Subject: FW: Discharge of Condition application A-86-20-DOC - Manor Nursery, High Street, Angmering Southern Water Ref 034392 1 of 2

Please upload onto Ocella the email trail below which is a further consultation response from **Southern Water** to discharge of condition application **A/86/20/DOC** regarding Manor Nursery, High Street, Angmering.

This has clarified the situation for me and I can confirm condition 20 can be discharged.

DRAWN M Pacifico		DATE May 2019	PROJECT NO. 22995
ENGINEER S Magowan		CHECKED	REV.
SCALE As Shown @ A1		DRG. NO. 105	REV. A

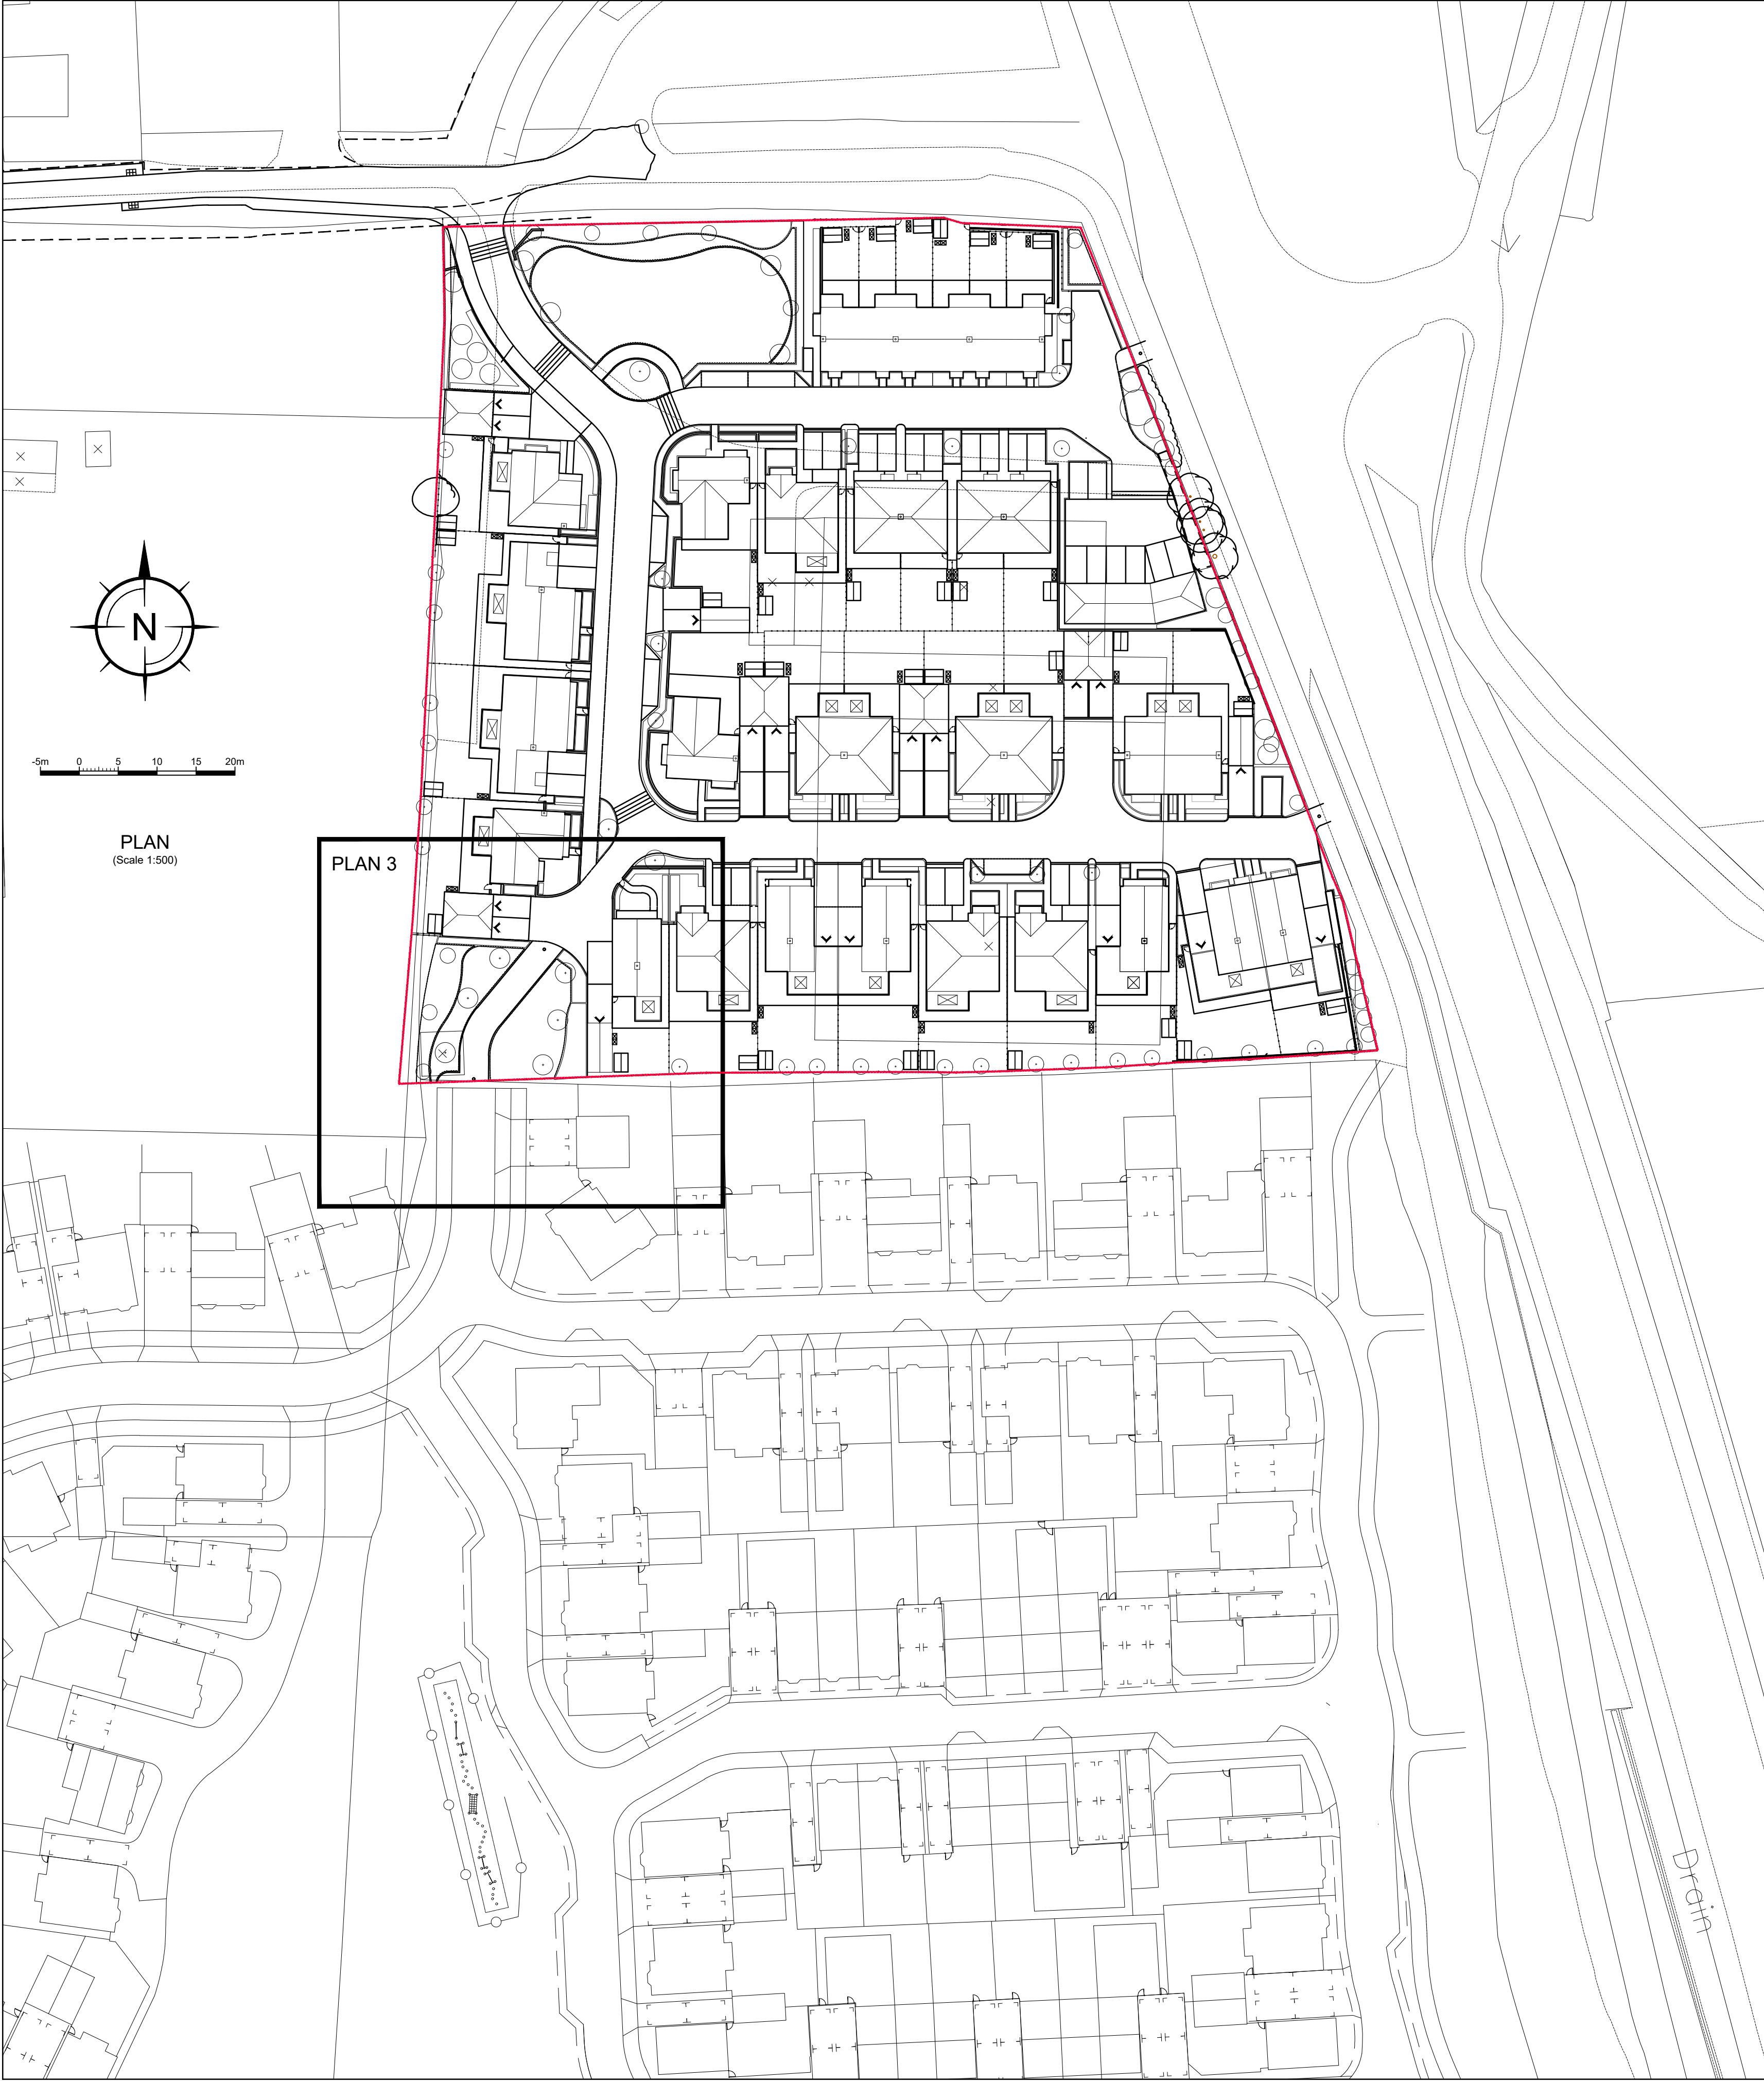
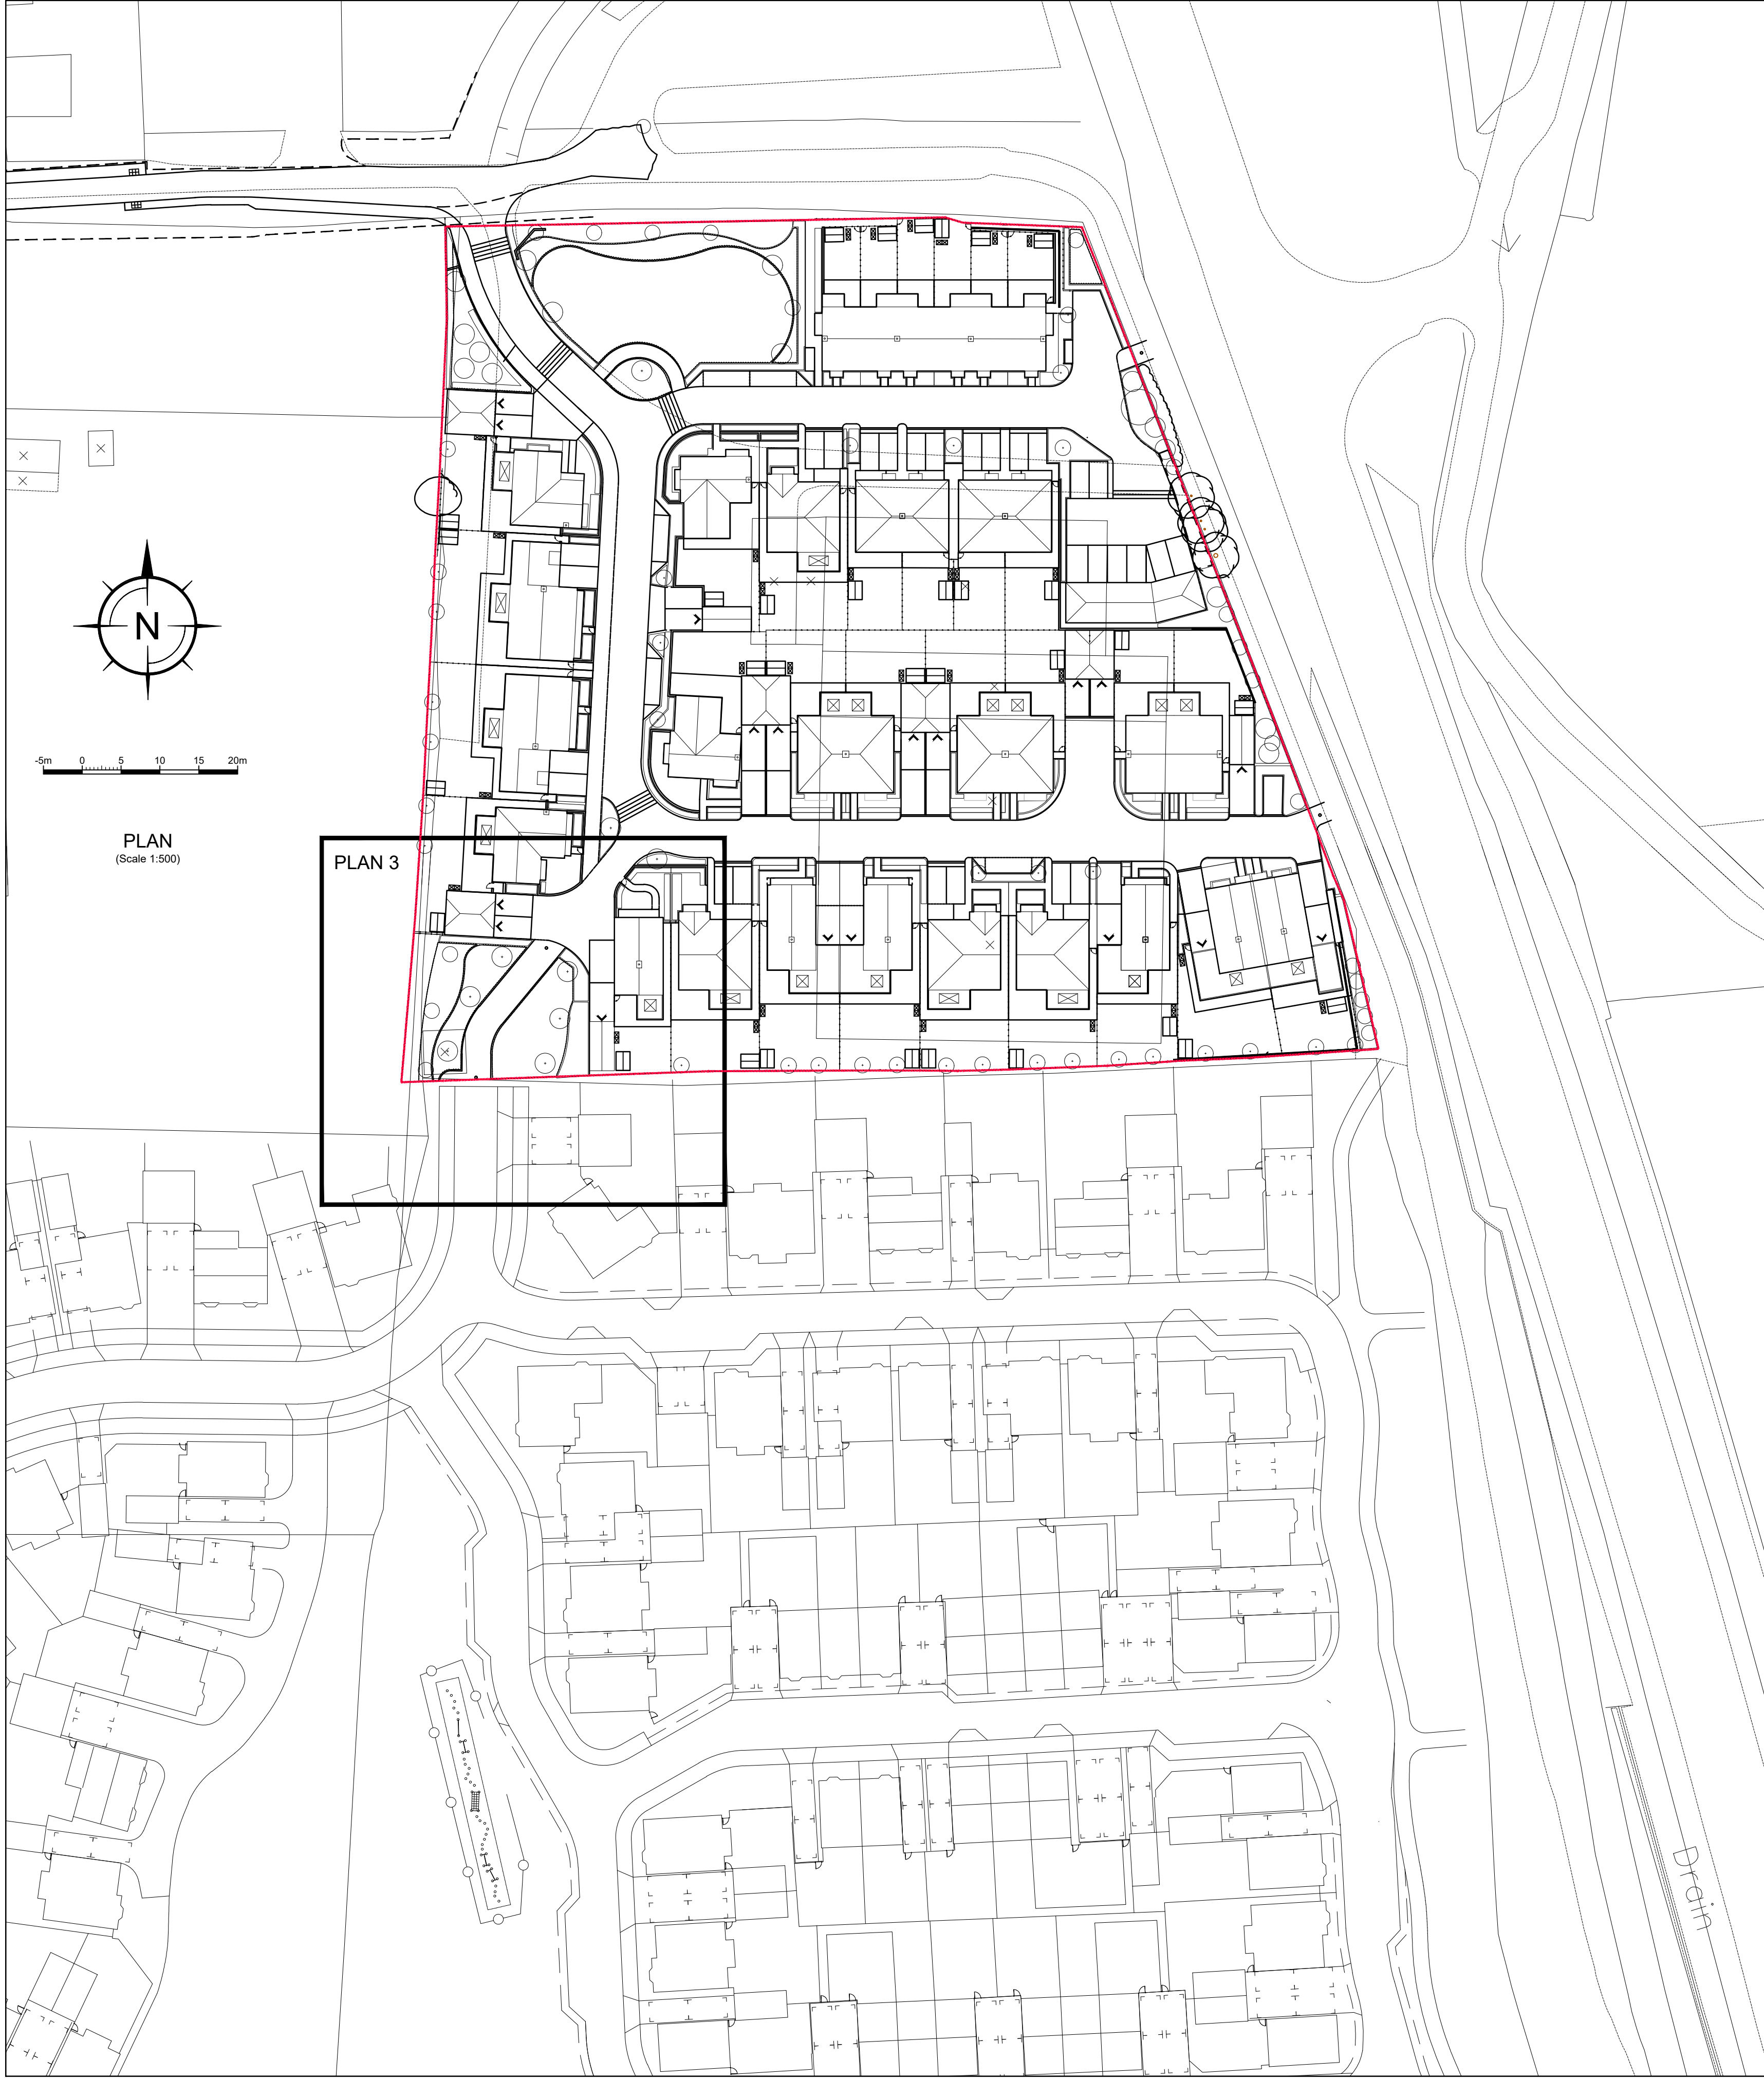
We have attached plan 110A which details the dimensions to the soakaways from the water main at 7.26m, 7.77m and 7.73m. Southern Water's published stand off distances to soakaways for a water main of less than 250mm diameter and less than 3.5m deep is 6m. The Southern Water letter notes that No Soakaways...should be located within 5m of public water main. The soakaways, at a distance greater than 7m from the water main, are not within the 5m requested or the 6m standoff distance for this size of water main.

Sorry for the delay in replying, if you could please quote our PLAN number in future correspondence this will speed things up for us (034392). In such instances Southern Water requires a 6m easement and therefore cannot approve the discharge of condition 20.

Southern Water's comments are noted with regard to the proposed soakaways being situated too close to the main in their current position therefore these have been relocated to provide a minimum offset of 5m from the main, as requested. Please refer to the attached amended plan which shows the soakaways positions in relation to the water main along with the previously proposed (3m) easement area.
